Application Reference: Y/70/22/DOC Site Name: Land at Blisham Road, Yapton	Initial Issue Date: 04/10/2022 Issue Date: 01/02/2024 Reviewer Reference:
---	---

Description of Works: Approval of details reserved by condition imposed under ref Y/91/17/OUT relating to Condition Nos 9 - surface water drainage and 27 - levels.

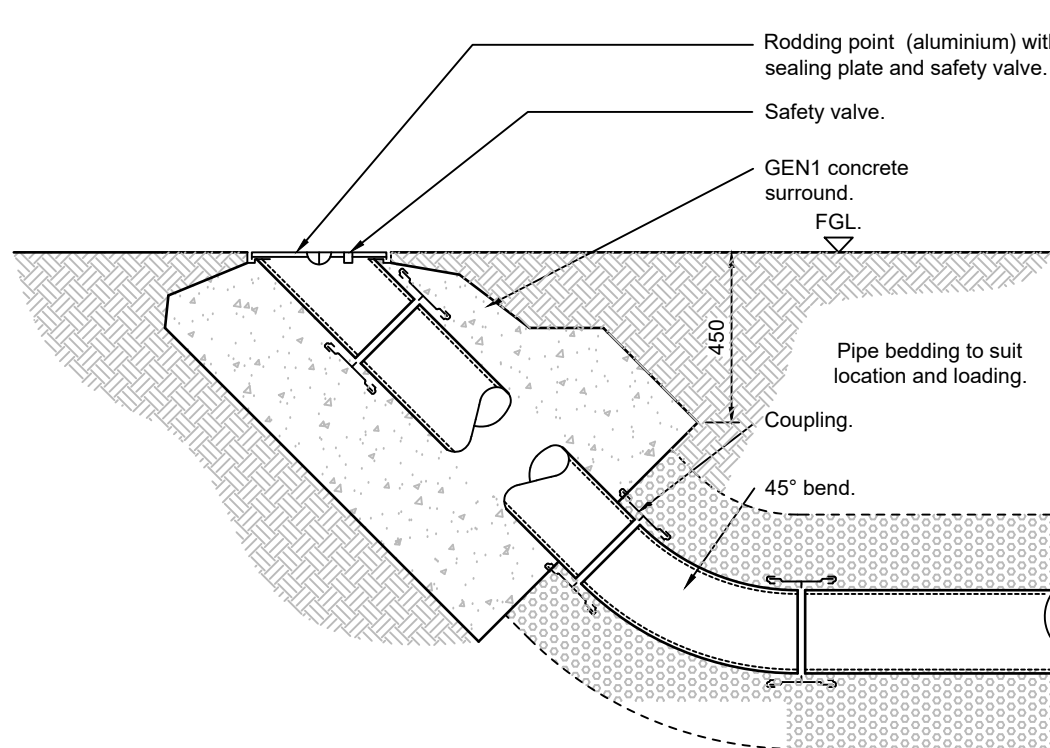
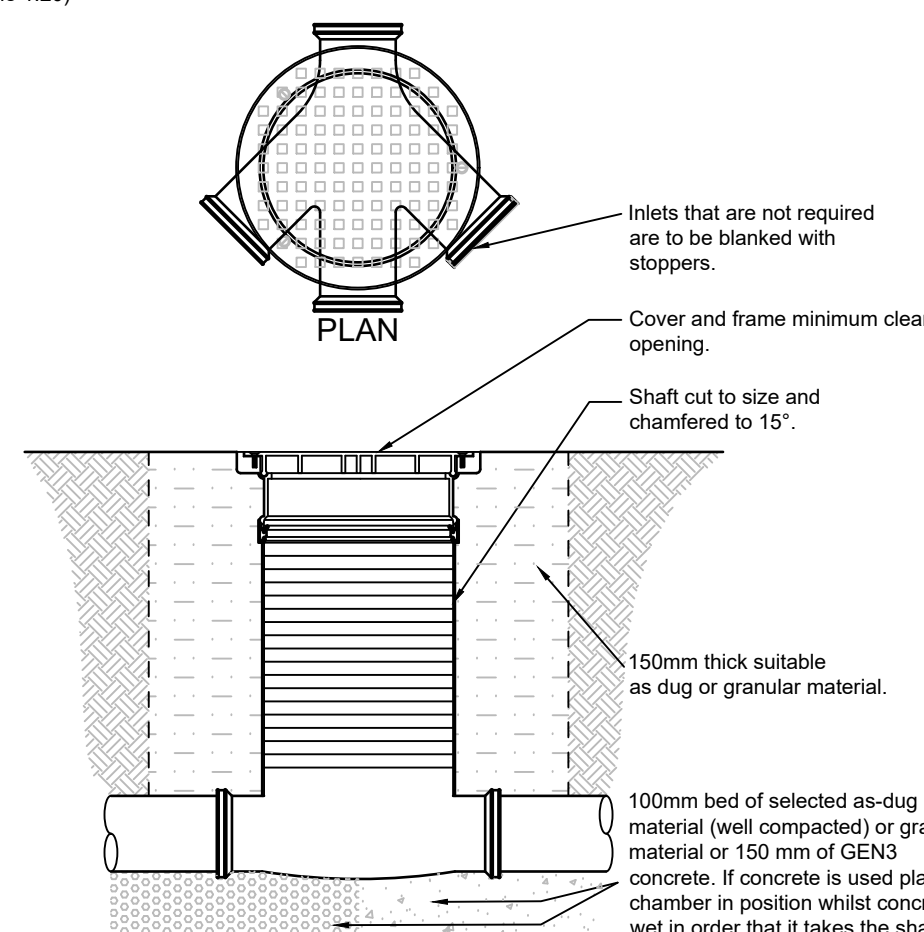
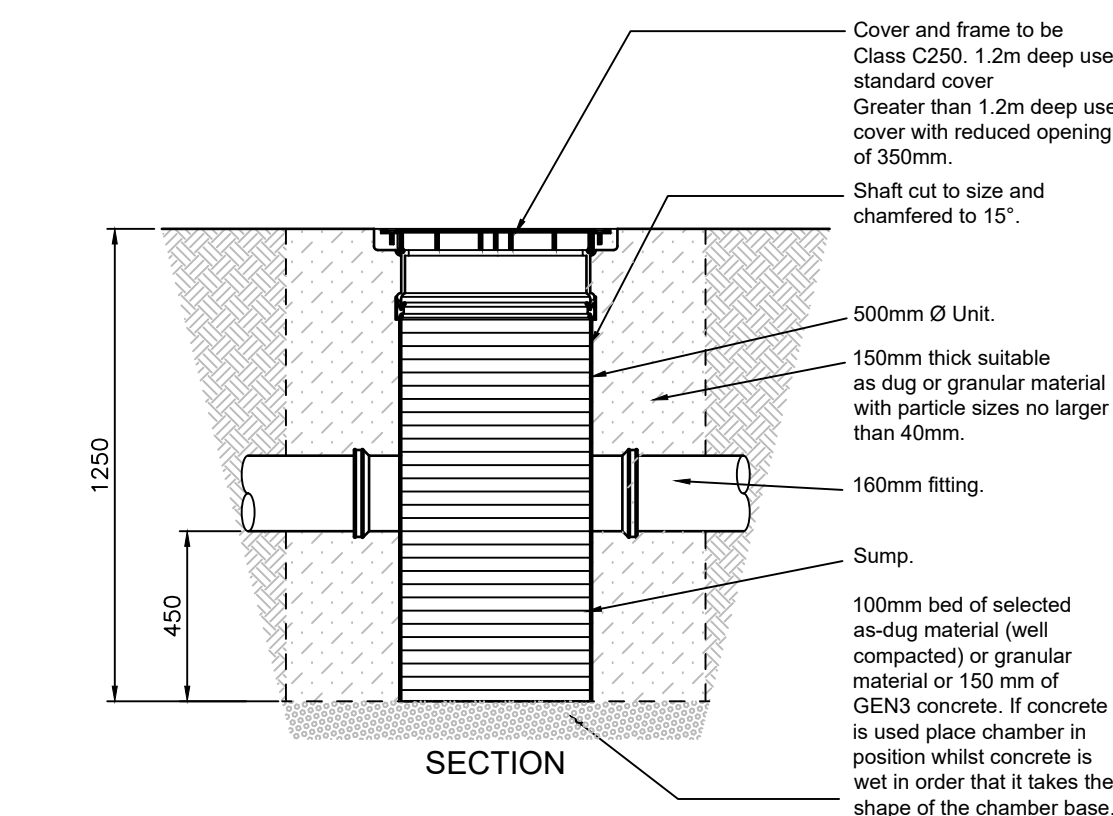
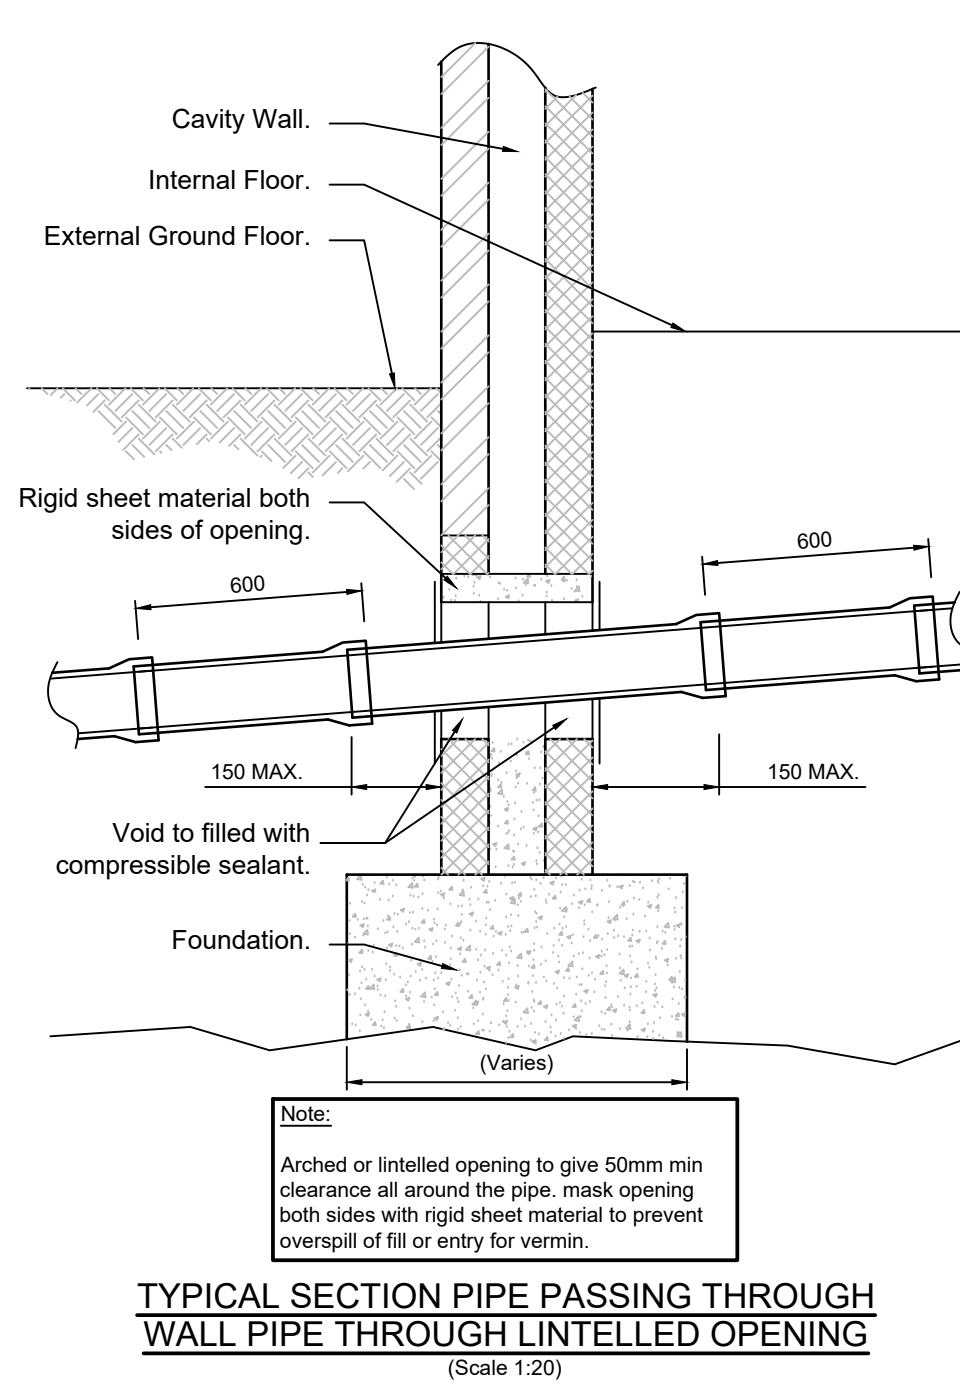
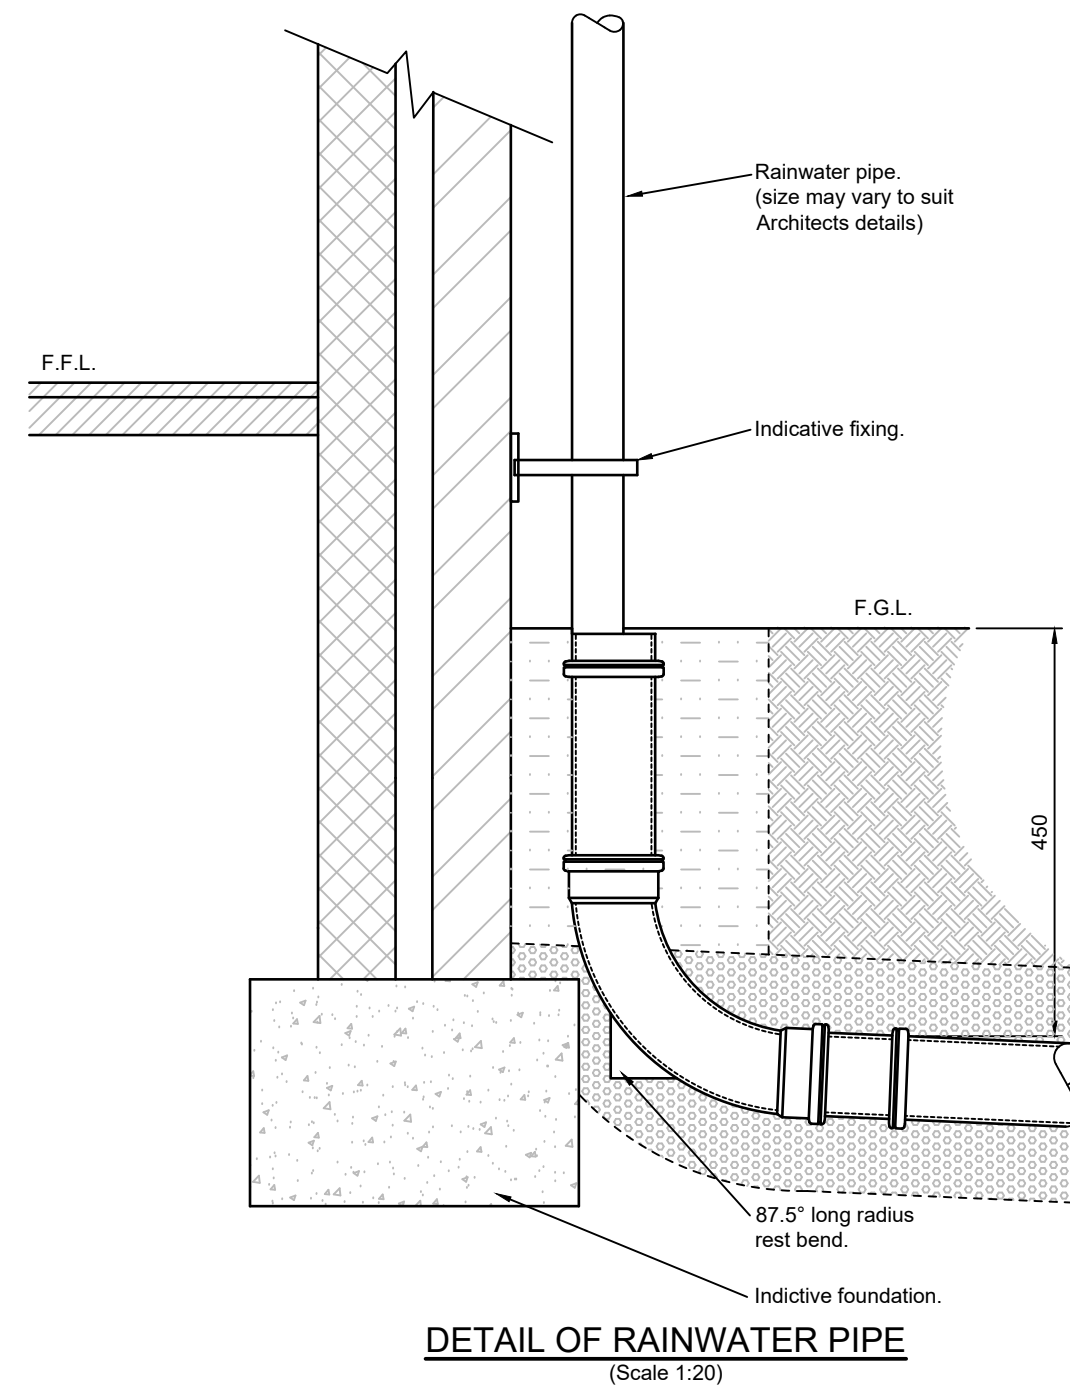
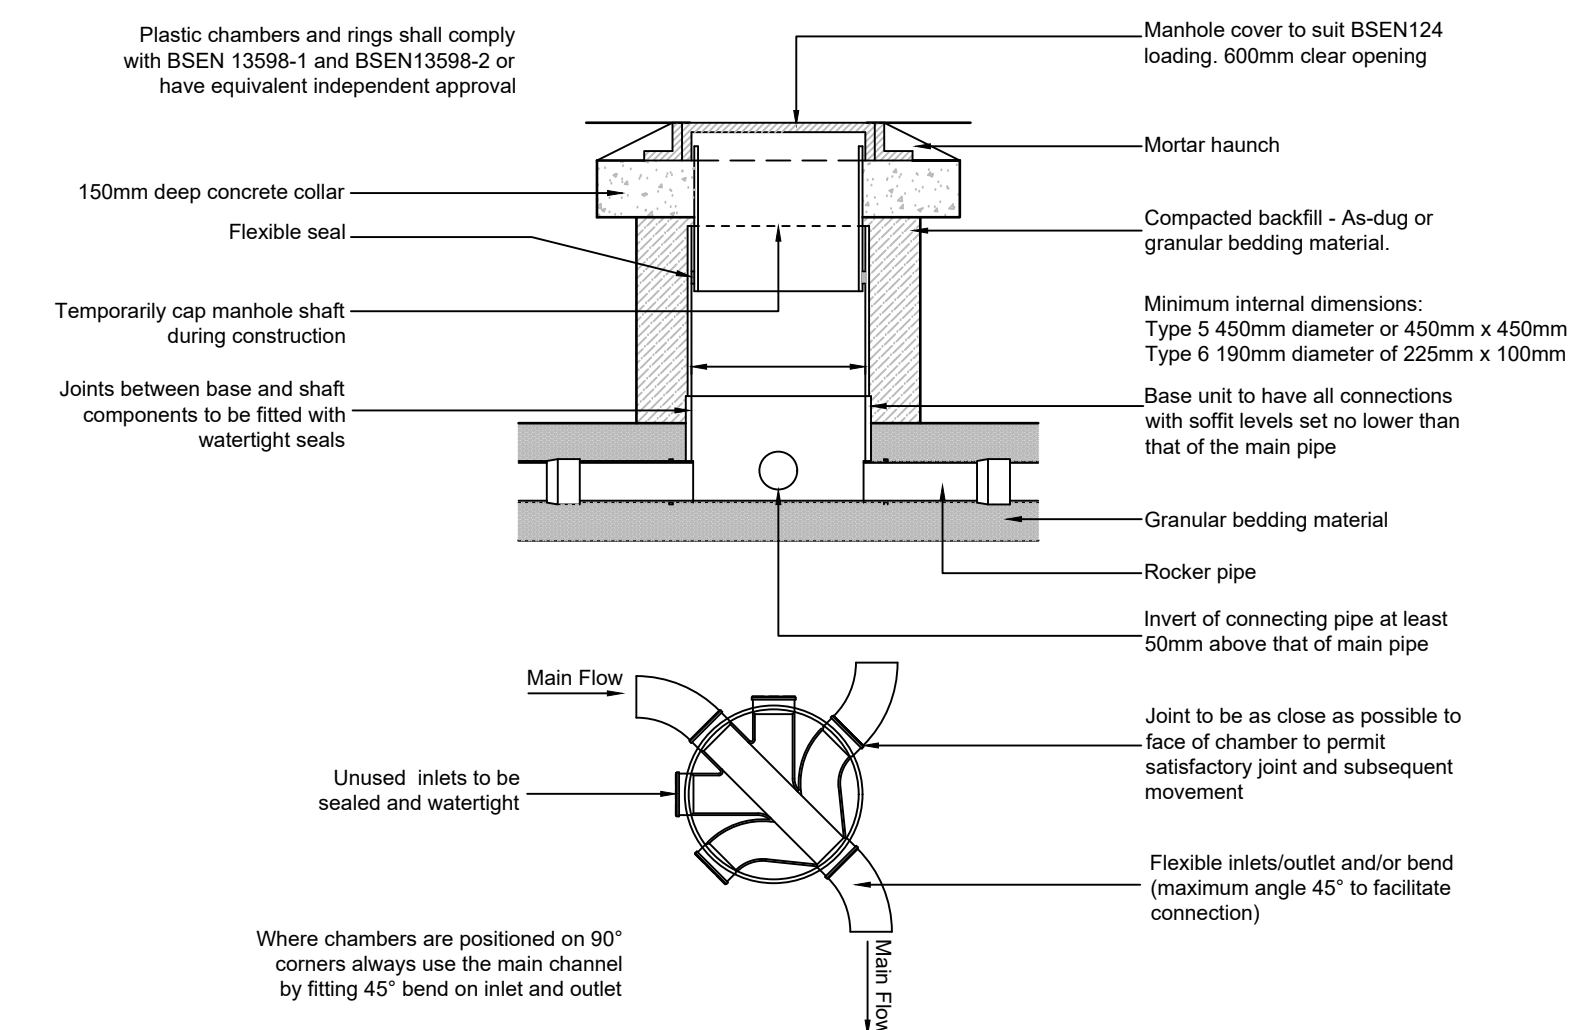
16.	Please provide a construction detail of permeable paving which clearly defines the construction, i.e. blocks, bedding, membranes, sub-base, tanking membrane. Materials and depths should be clearly defined.	The construction detail shown on drawing D1956-15.2 conflicts with that shown on D1956-15-3A. These need to be updated to ensure there is no conflicting information. In addition to this its not clear why part infiltration has not been sought in areas where the infiltration has demonstrated that this is achievable. The applicant should clarify clear reasons as to why infiltration techniques have not been used for the permeable paving in the areas within the vicinity of the following test locations: TP05; TP04; TP01. 08/2/2023- This has now been received and we have no further comments.	Closed
